CDR20002-R2-CD-redlines Summary_Markup Summary

CDR-20-002

R0.0

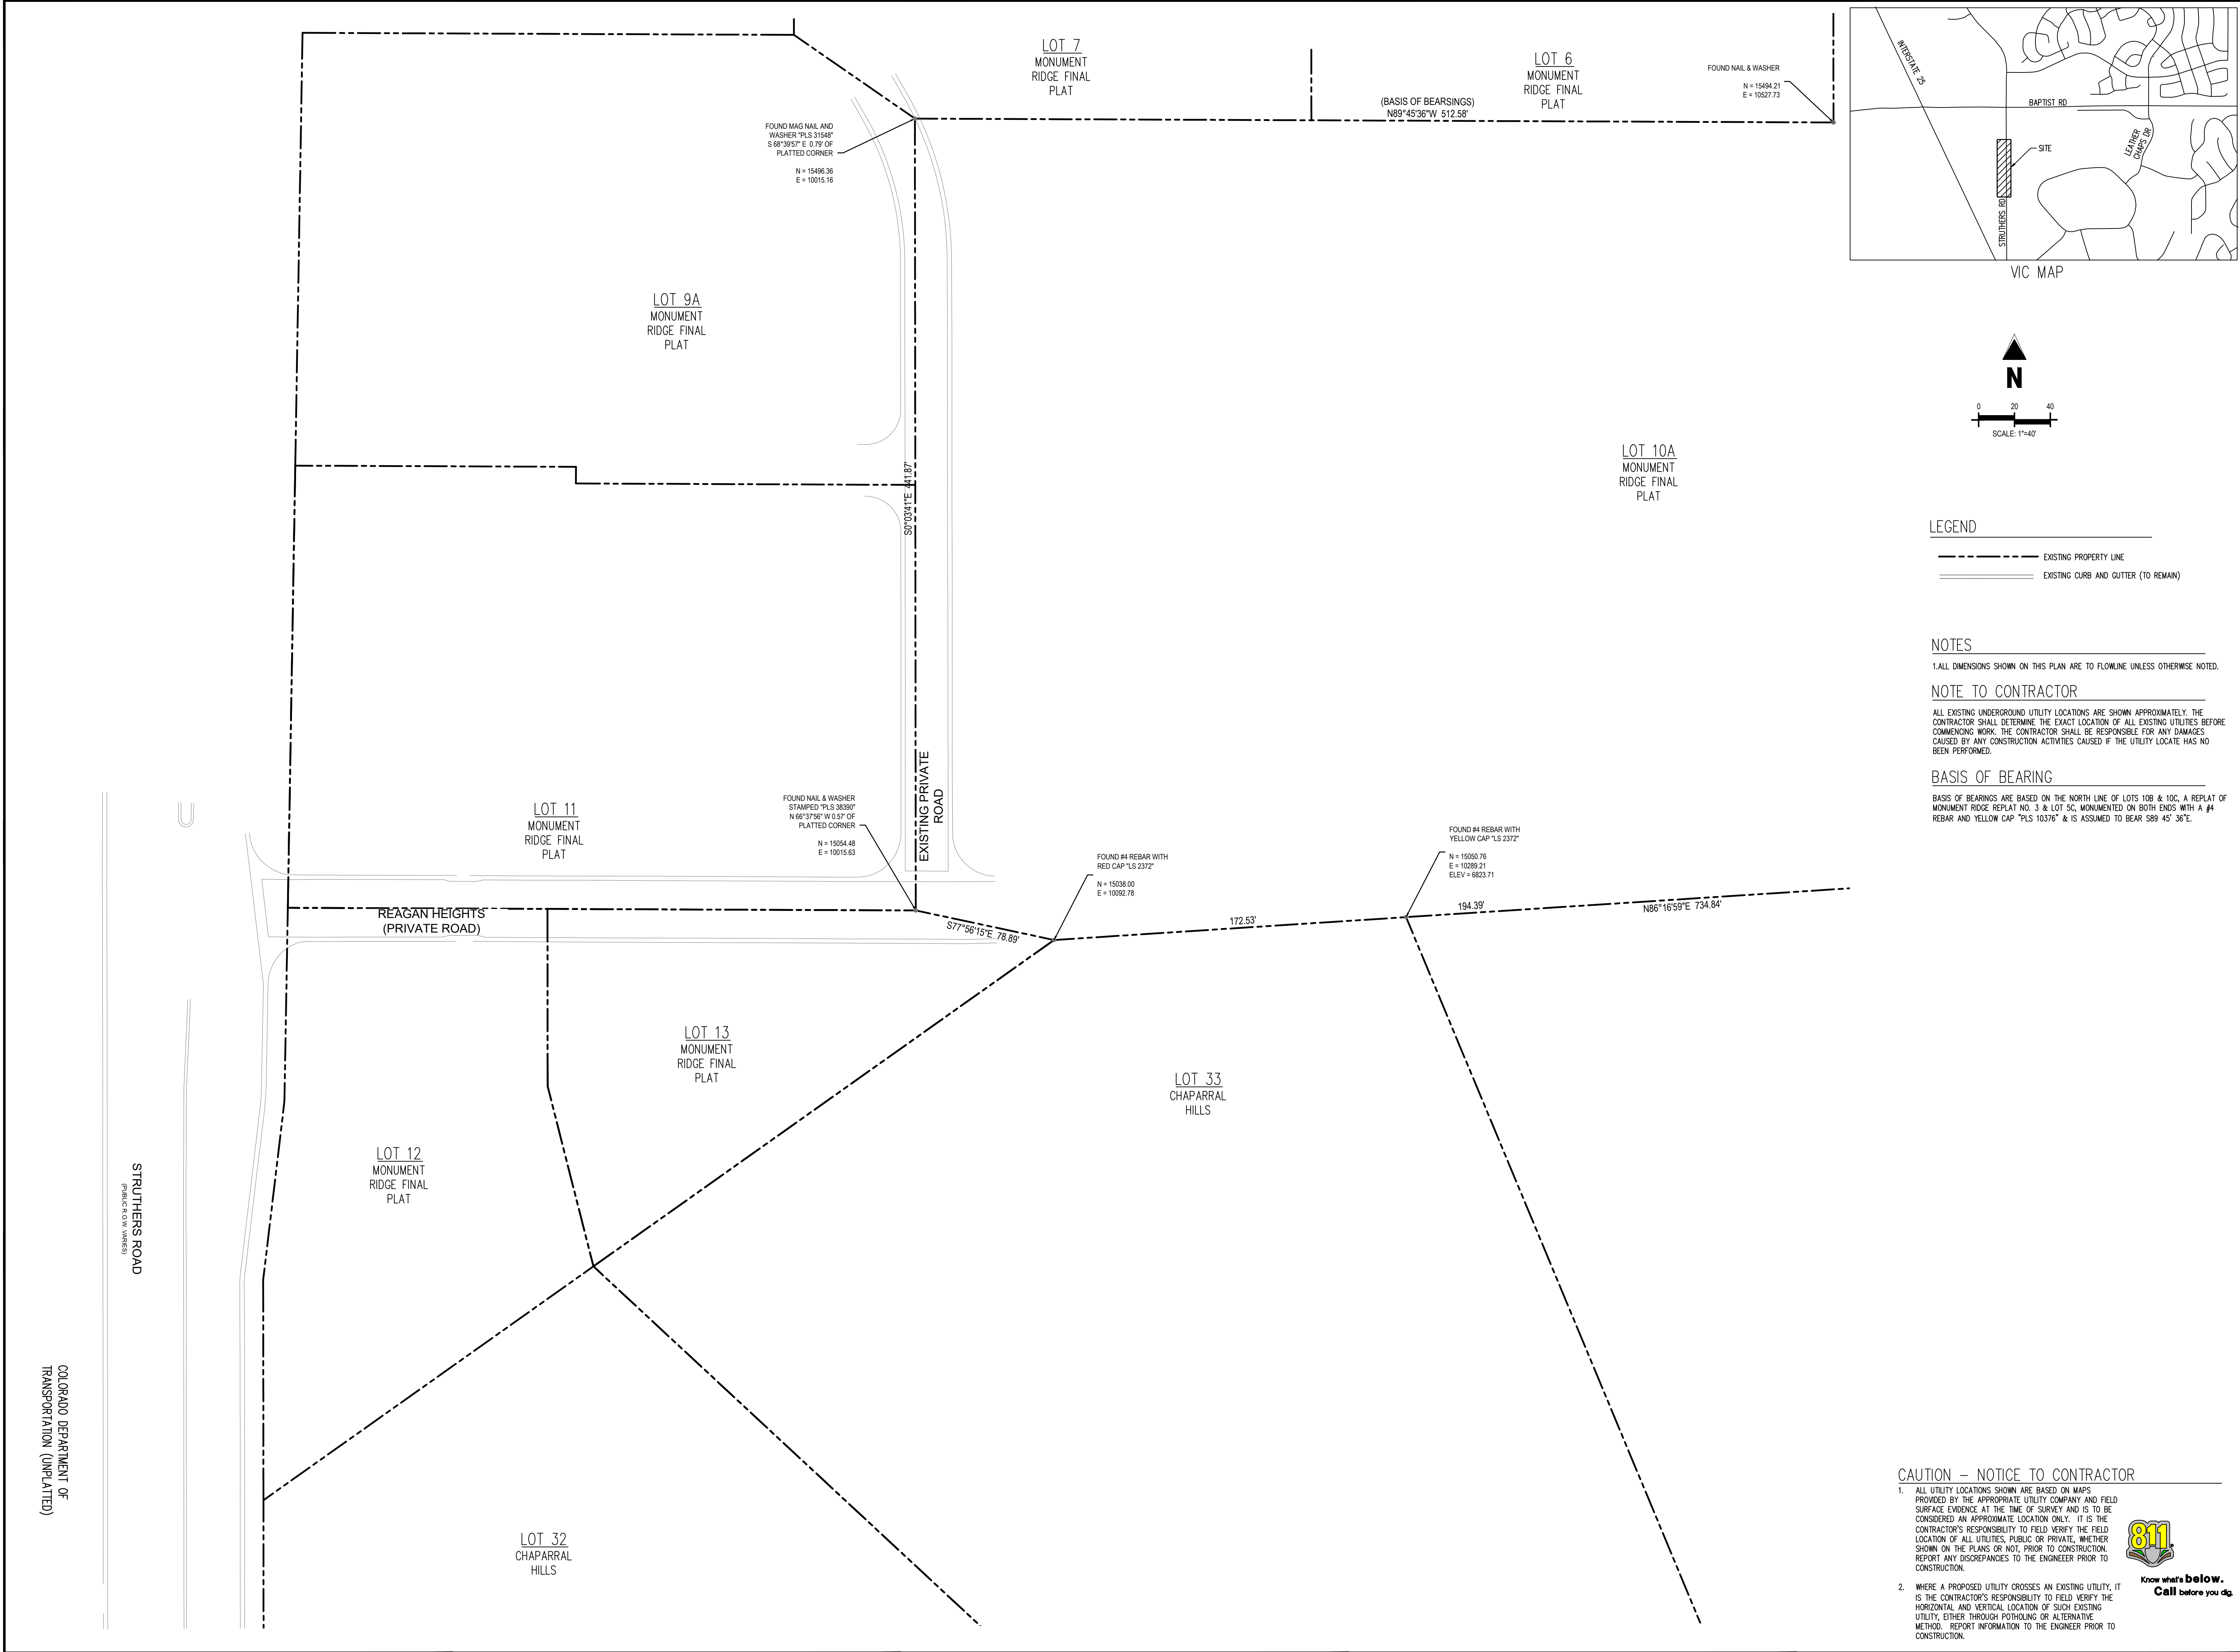
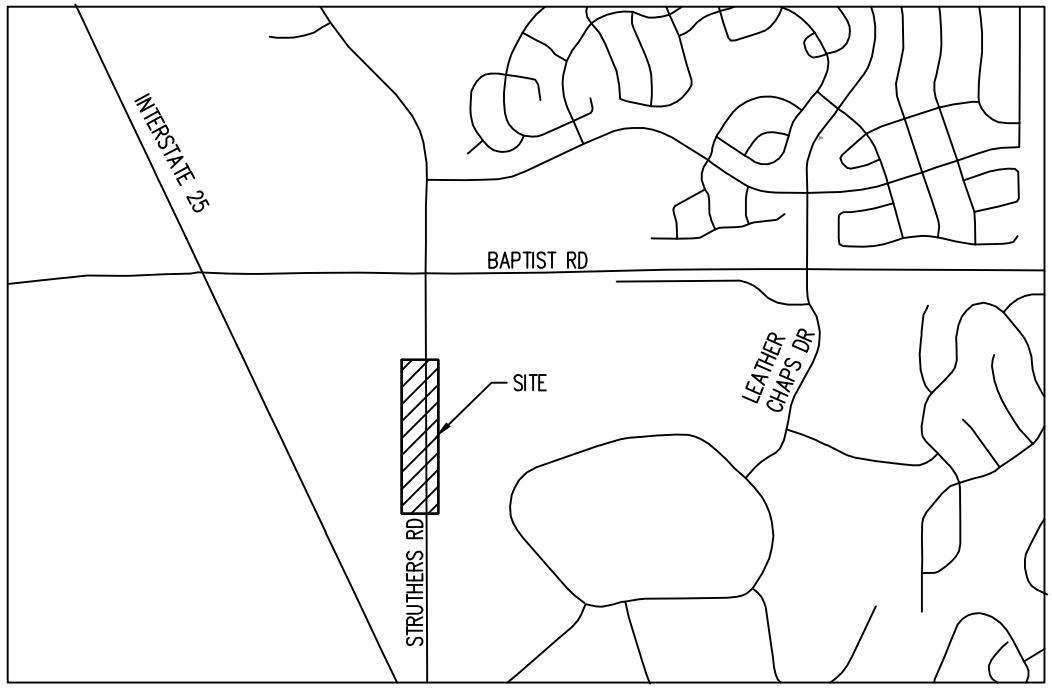
Subject: Callout
Page Index: 1
Date: 6/29/2020 11:29:42 AM
Author: dsdrice
Color: ■
Layer:
Space:
Page Label: [1] R0.0

These detailed plans and specifications were prepared under my direction and supervision. Said plans and specifications have been prepared according to the criteria established by the County for detailed roadway, drainage, grading and erosion control plans and specifications, and said plans and specifications are in conformity with applicable master drainage plans and master transportation plans. Said plans and specifications meet the purposes for which the particular roadway and drainage facilities are designed and are correct to the best of my knowledge and belief. I accept responsibility for any liability caused by any negligent acts, errors or omissions on my part in preparation of these detailed plans and specifications.

Subject: Callout
Page Index: 1
Date: 6/29/2020 11:31:18 AM
Author: dsdrice
Color: ■
Layer:
Space:
Page Label: [1] R0.0

I, the owner/developer have read and will comply with the requirements of the grading and erosion control plan and all of the requirements specified in these detailed plans and specifications.
